Cle Elum Properties Plat P-06-15

STAFF REPORT

TO: Kittitas County Planning Commission
FROM: Dan Valoff, Staff Planner
DATE: July 10, 2007
SUBJECT: Cle Elum Properties Preliminary Plat (P-06-15)

SUBJECT: Cle Elum Properties Revised Plat

Drawing file: LP-06-00015 Cle Elum Properties / P-06-15 Cle Elum Properties 000002.pdf

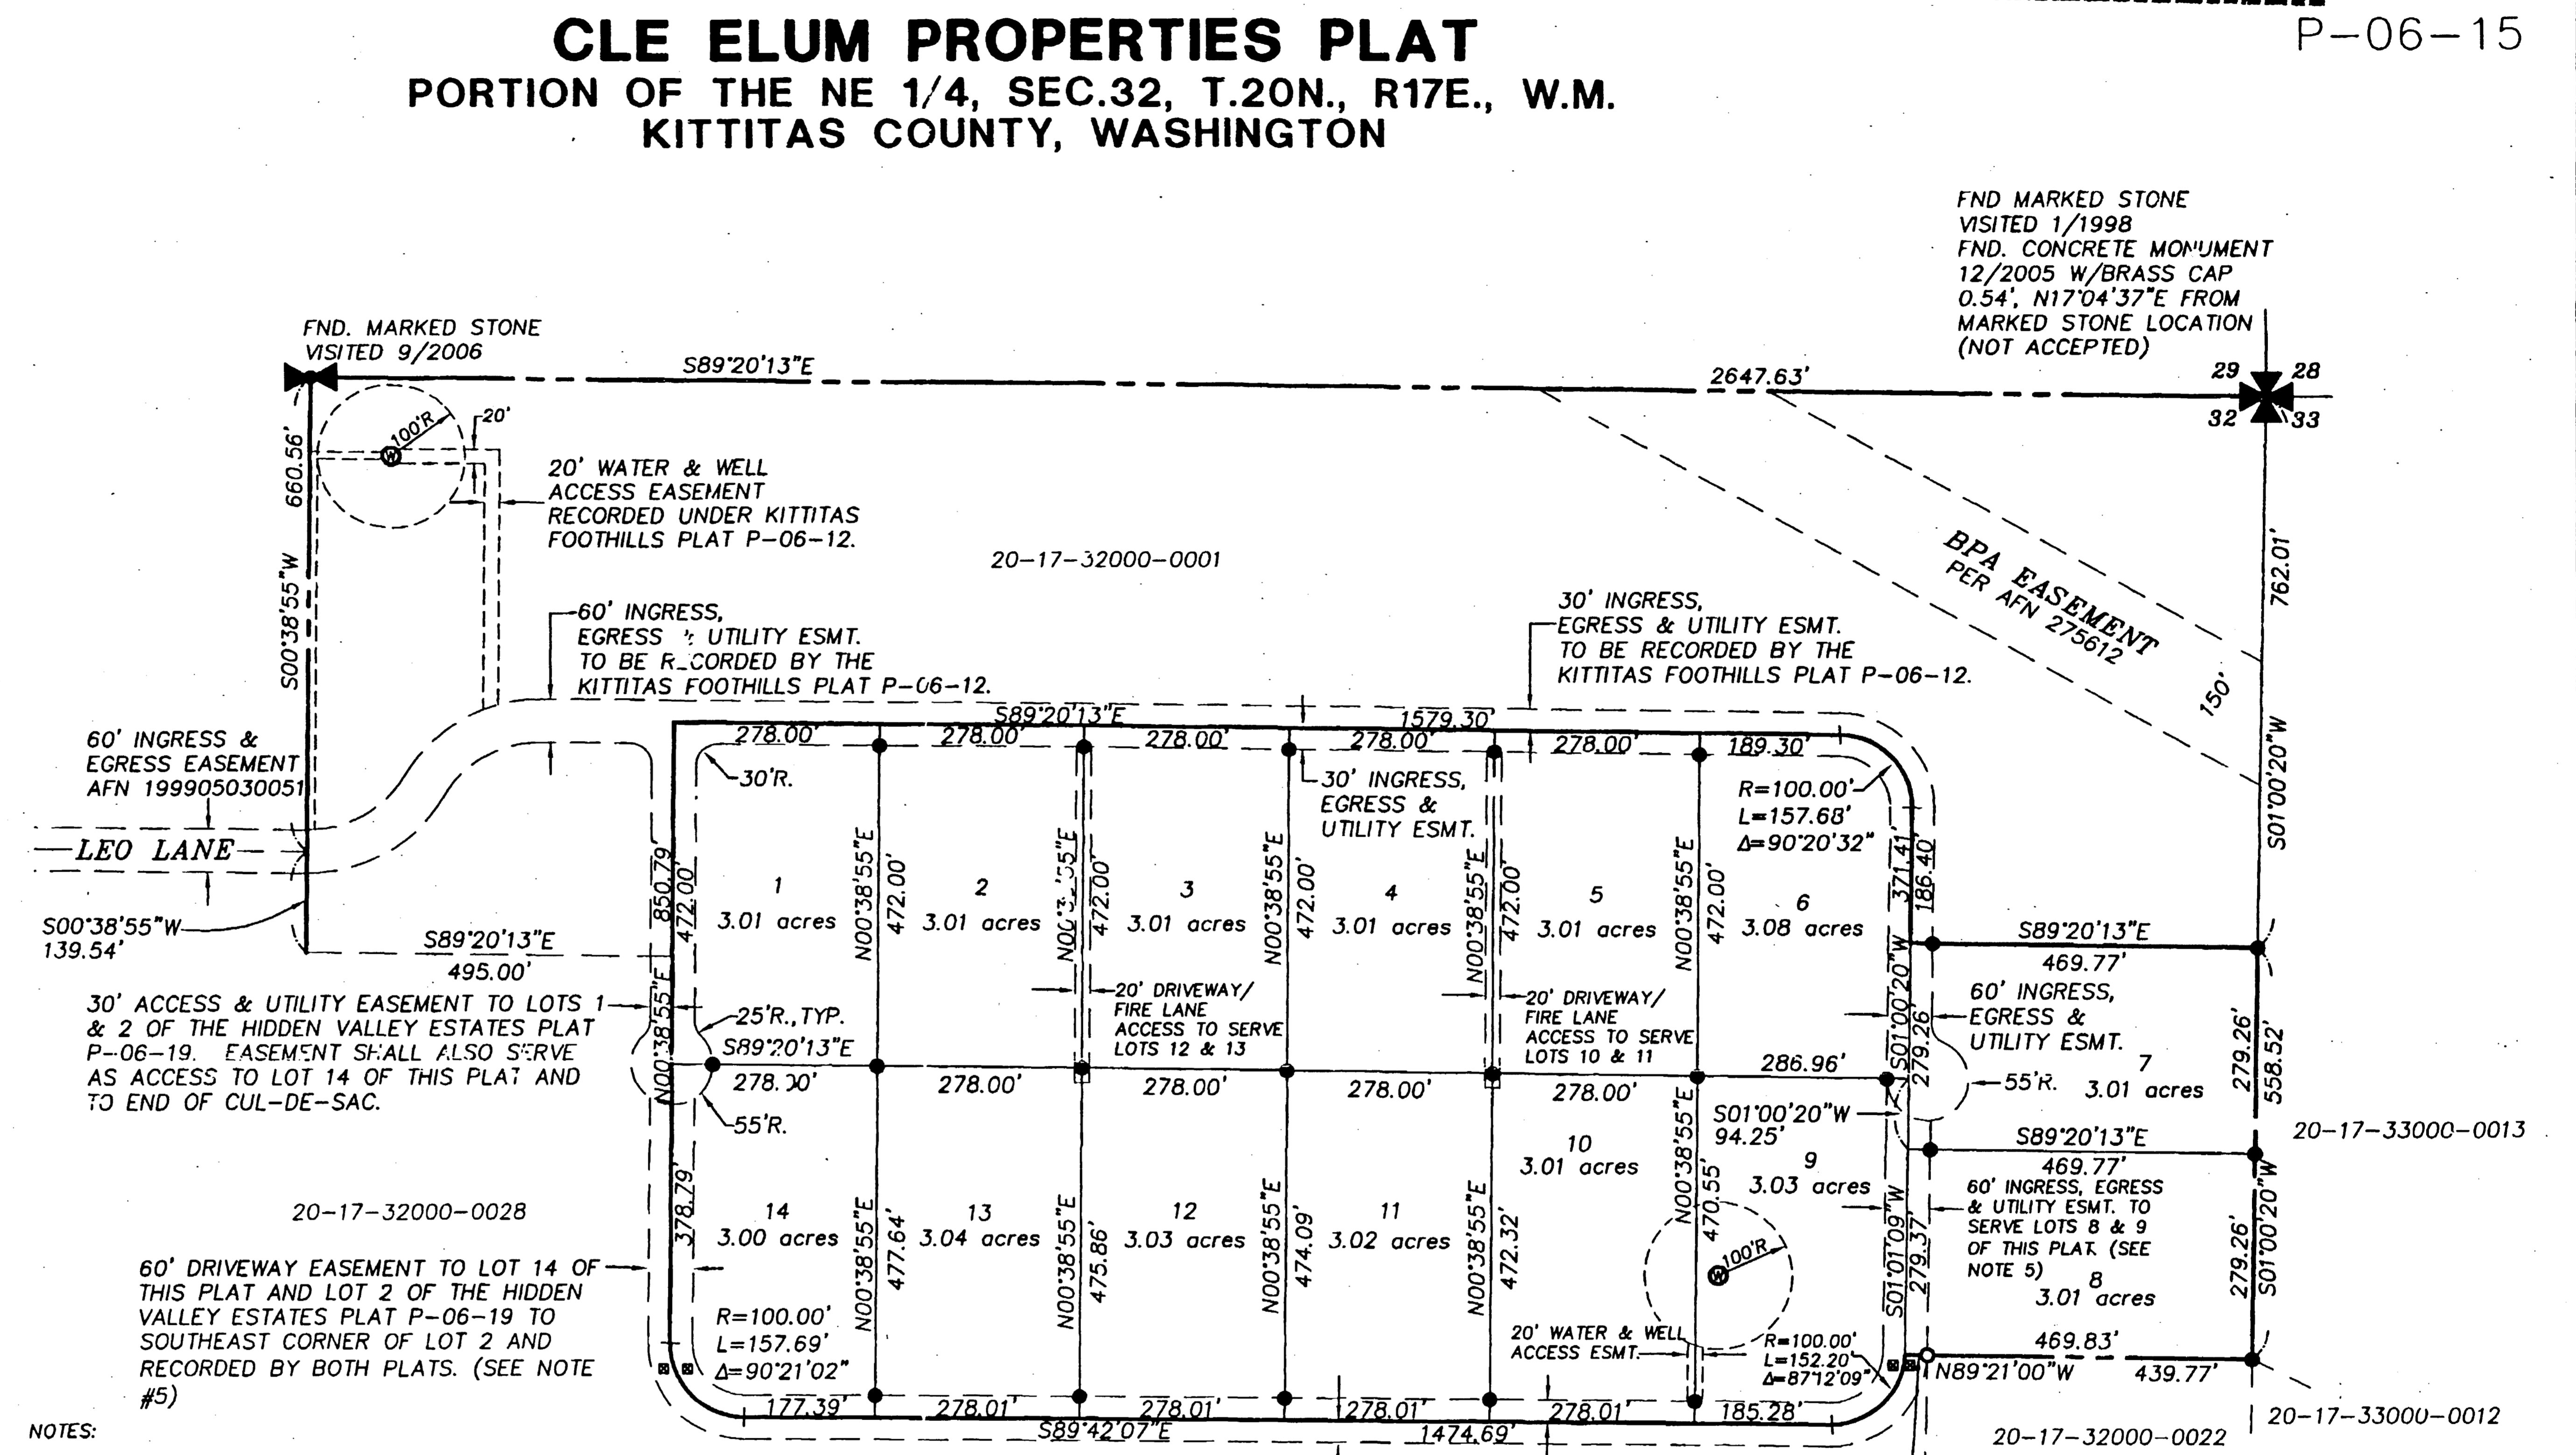
2. Changes to the Circular Road System: The original preliminary plat depicted a 60' access and utility easement that, essentially, serves the lower lots 9 thru 14. The revised application changes the 60' access and utility easement to a "non-motorized trail and utility easement and provides access to lots 10, 11, 12 and 13 via (2) separate joint-use driveways, which is allowed by current Kittitas County Road Standards.

3. Revised Access to Serve Additional Lots: A note was added to the revised application that states: *Easement shall also serve as access to lots 1 & 2 of the Hidden Valley Estates Plat.* It is my understanding that the existing easement that originates from Leo Lane only allows access to the (2) parent parcels for the Kittitas Foothills Plat (20-17-32000-0001) and the Cle Elum Properties plat (20-17-32000-0005) and access to the Hidden Valley Estates is not allowed. This issue shall be resolved prior to final plat approval.

- a. Cul-de-sac design, reference AASHTO.
 - b. Contact the Fire Marshall regarding any additional cul-de-sac requirements.
7. Lots 8 & 9, 10 & 11 and lots 12 & 13 Joint-Access Driveway: Individual joint-use driveways shall serve lots 8 & 9, 10 & 11 and lots 12 & 13, as shown on the face of the plat. These joint-use driveways shall serve no more than two tax parcels each and meet or exceed the requirements for a joint-use driveway as described below.

8. Lot 14 Access: The revised application proposes lot 14 to be served via the 30' access easement, as shown on the face of the plat. If it is determined that this access can also serve lots 1 and 2 of the Hidden Valley Estates Plat then 3 or more lots would be served and a High-Density Private Road shall be required. This would require a minimum 40' wide access easement as well as meeting the following requirements:

5. Private Road Improvements: The main access road that originates from Leo Lane shall meet or exceed current Kittitas County Road Standards for a High-Density Private Road and serve no more than 40 tax parcels. See current Kittitas County Road Standards, 9/6/05 edition.

- a. Access easements shall be a minimum of 20' wide. The roadway width shall have a minimum width of 12'.
 - b. The surface requirement is for a minimum gravel surface depth of 6".

- a. Access easements shall be a minimum of 40' wide. The roadway shall have a minimum width of 20', with 1' shoulders, for a total width of 22'.
- b. Minimum centerline radius will be 60'.
- c. Surface requirement is for a minimum gravel surface depth of 6".
- d. Maximum grade 8% flat, 12% rolling or mountainous.
